Application M/56/15/HH: 31 Sea Way, Middleton-On-Sea, West Sussex, PO22 7RZ

I wish to enter my objection to the above proposed development on the following grounds:

Proposed Elevations  
Sections B-B  
C-C  
D-D

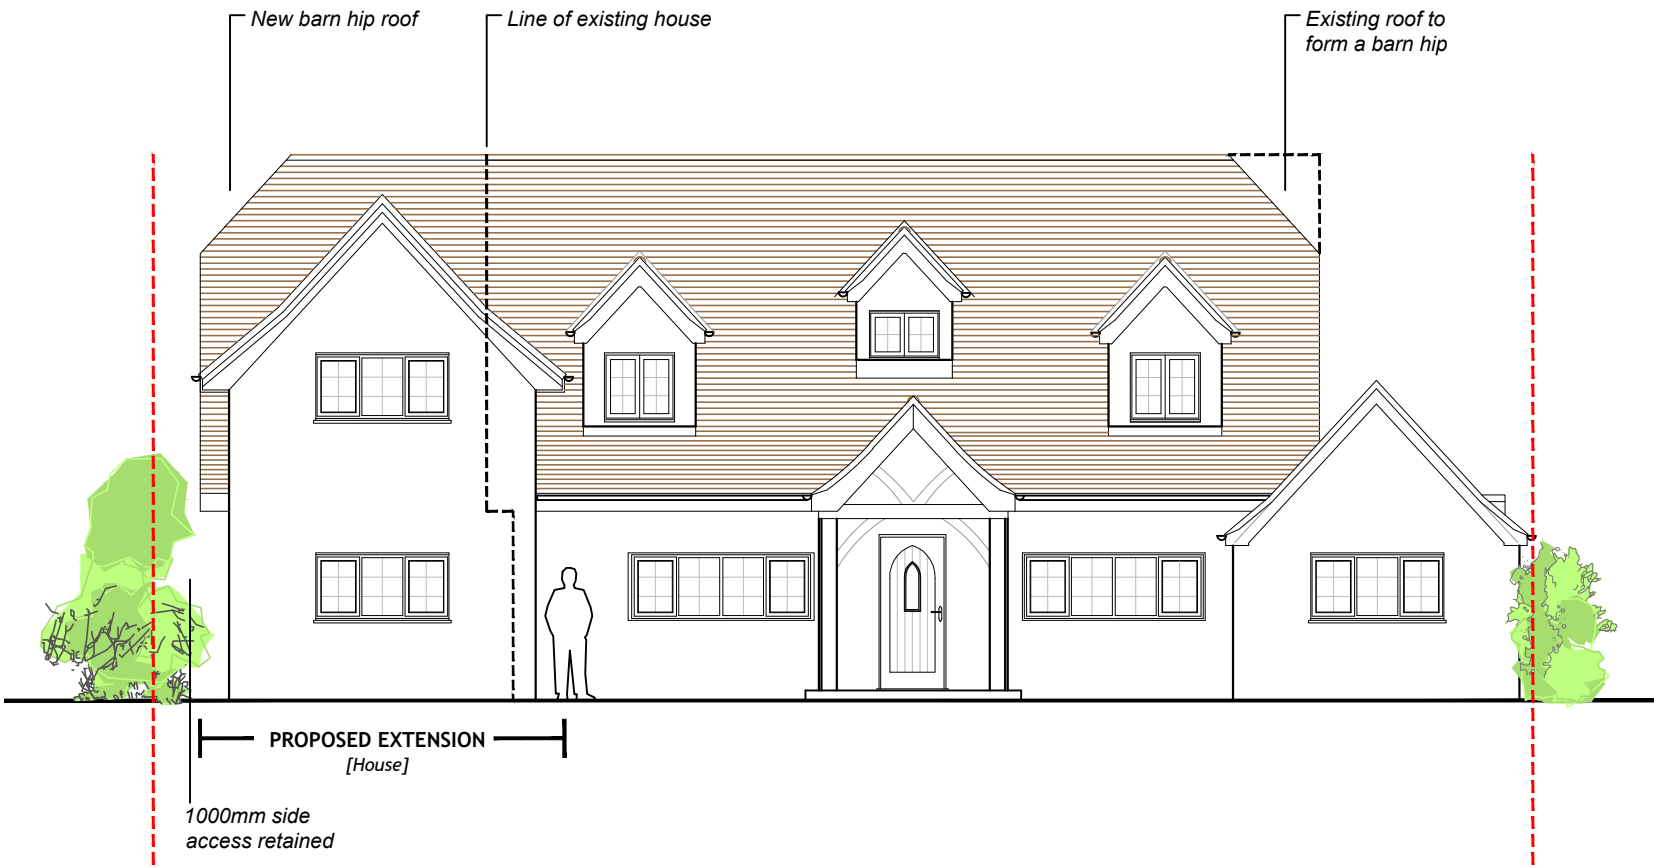
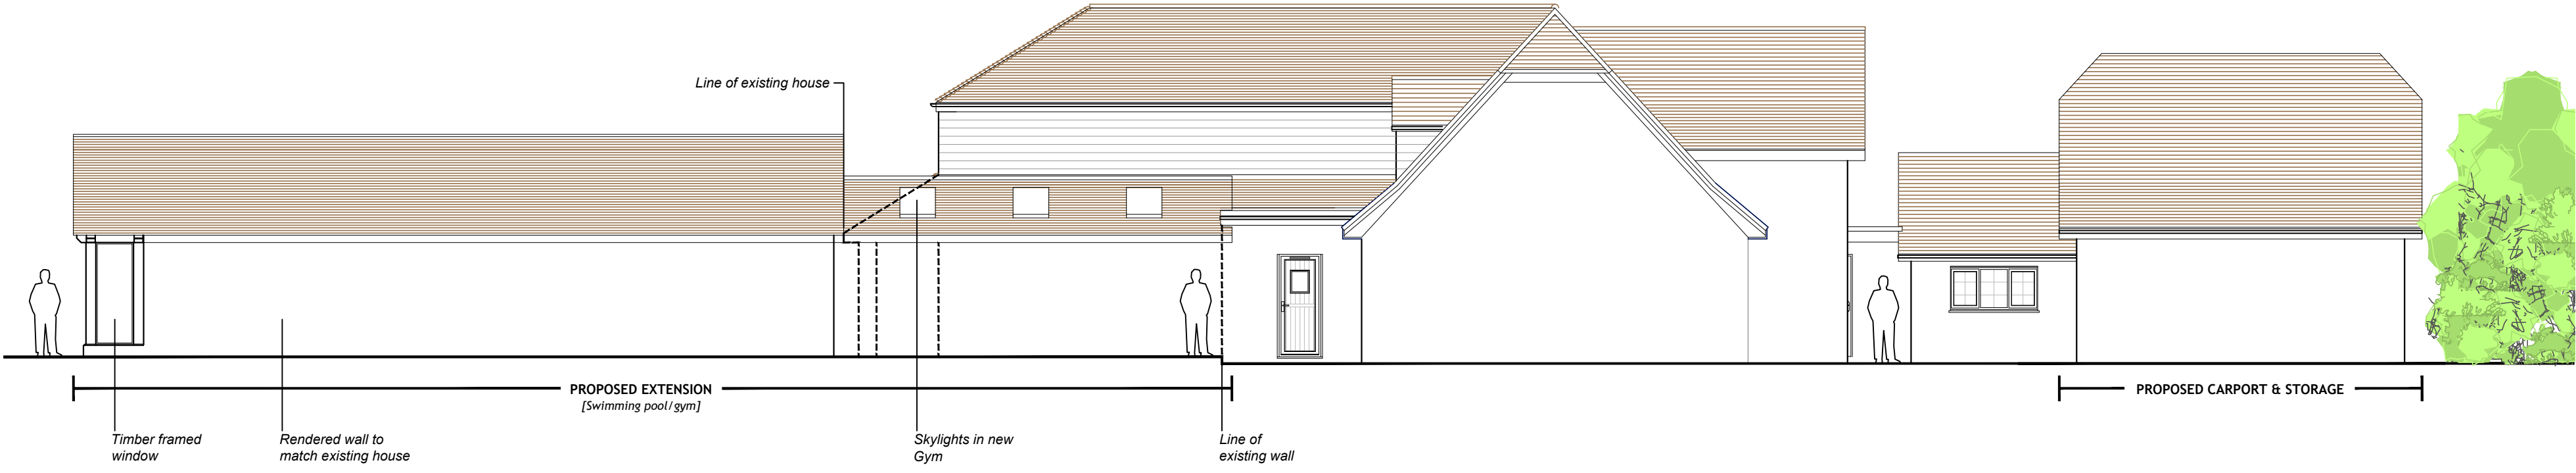
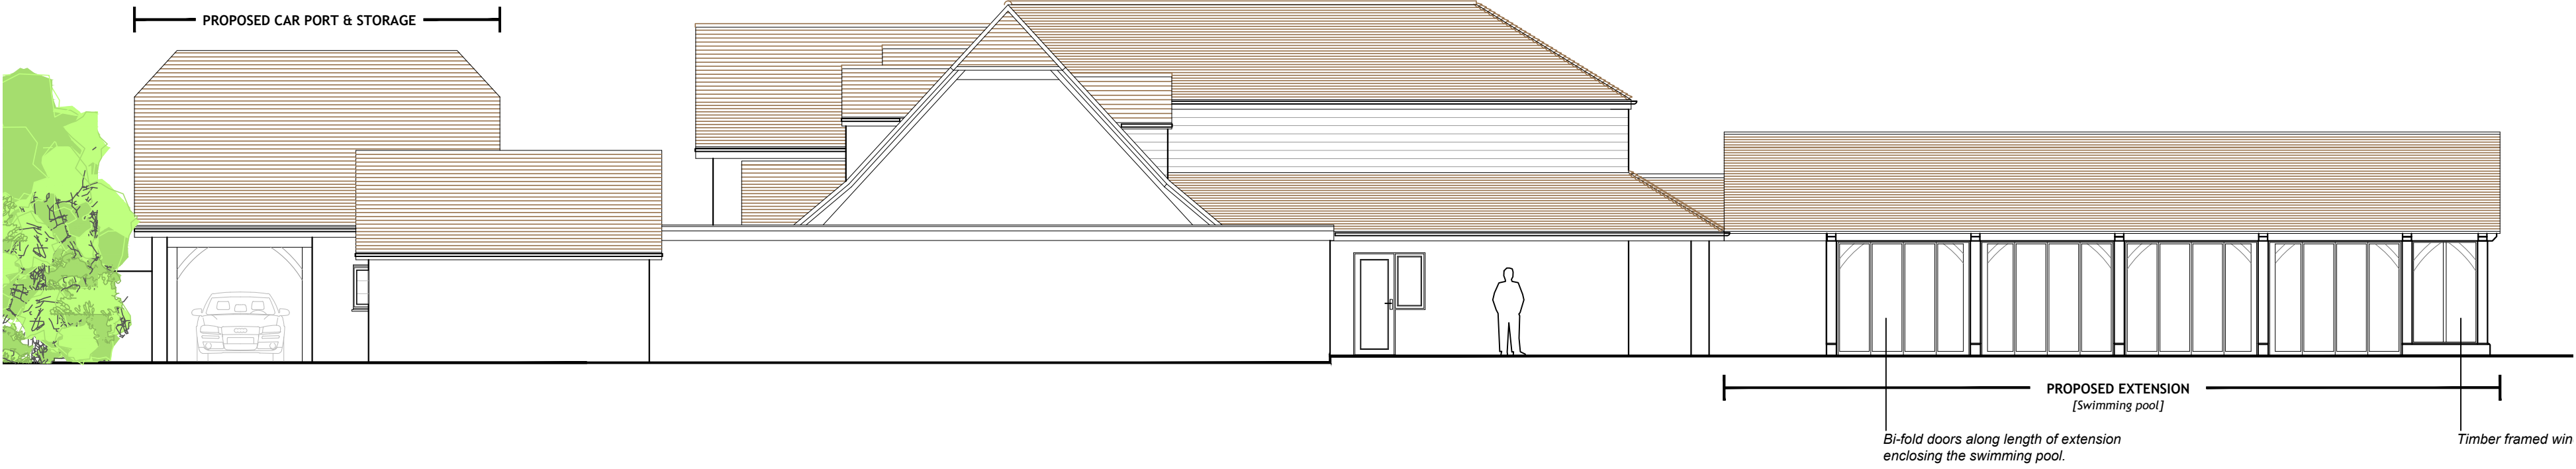
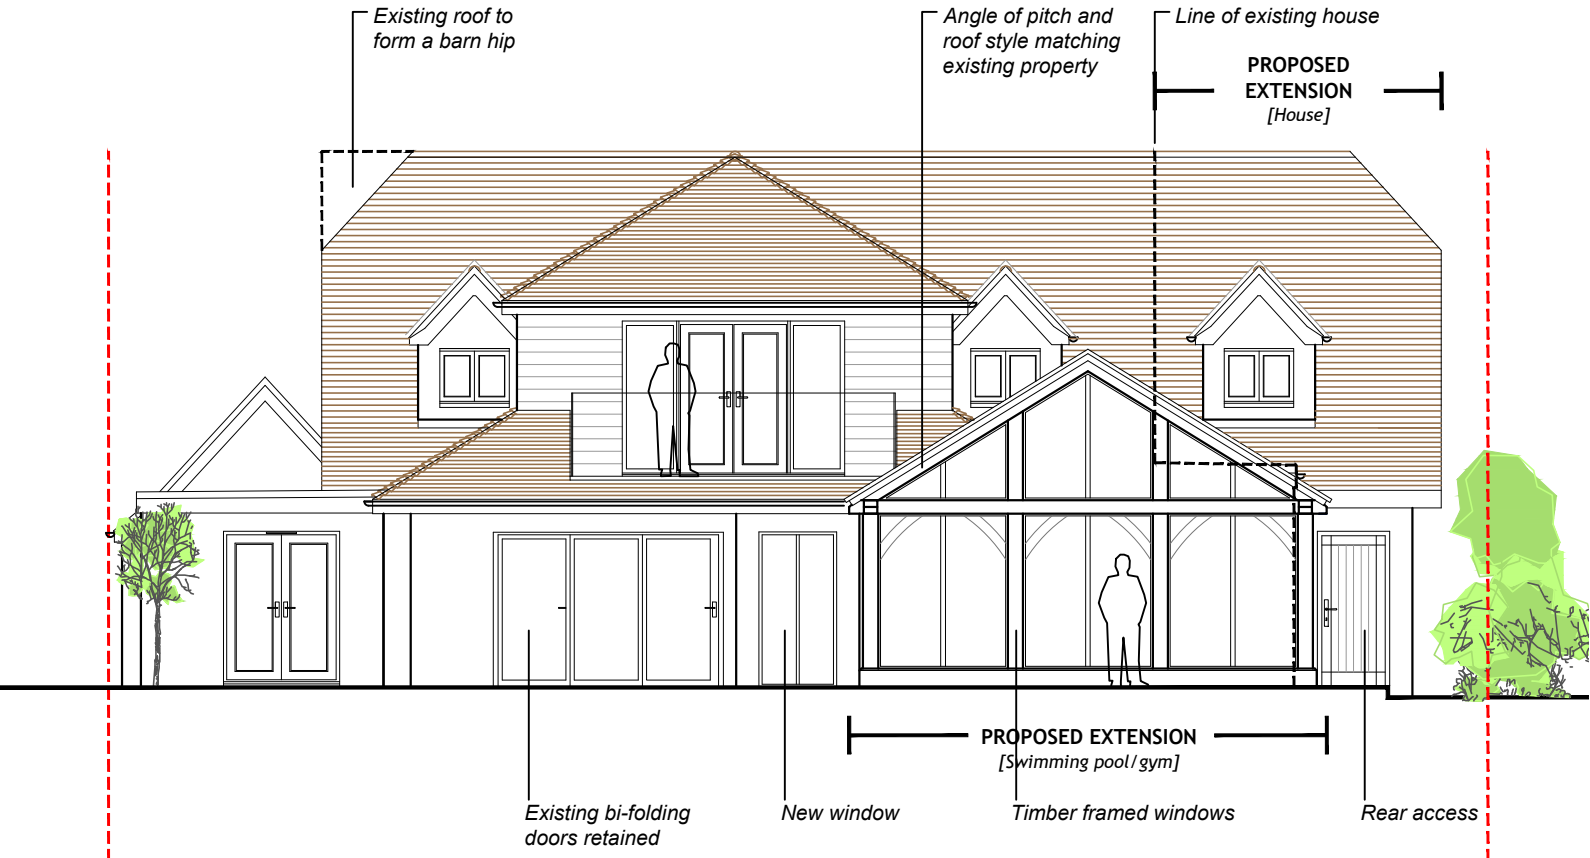
4. The bulk of the 'blind' wall and high pitched roof of the proposed garage building so close to the boundary line at both the east and north. The long bulk of the building will seem quite dominating – even if the current hedging or new planting or indeed a wall were in place. Again the precedent of building so close to the boundary of a property close fronting

the road is of major concern. I am unsure why the building needs to be so high if it is not intended to use the roof space for 'accommodation' of some sort in the future
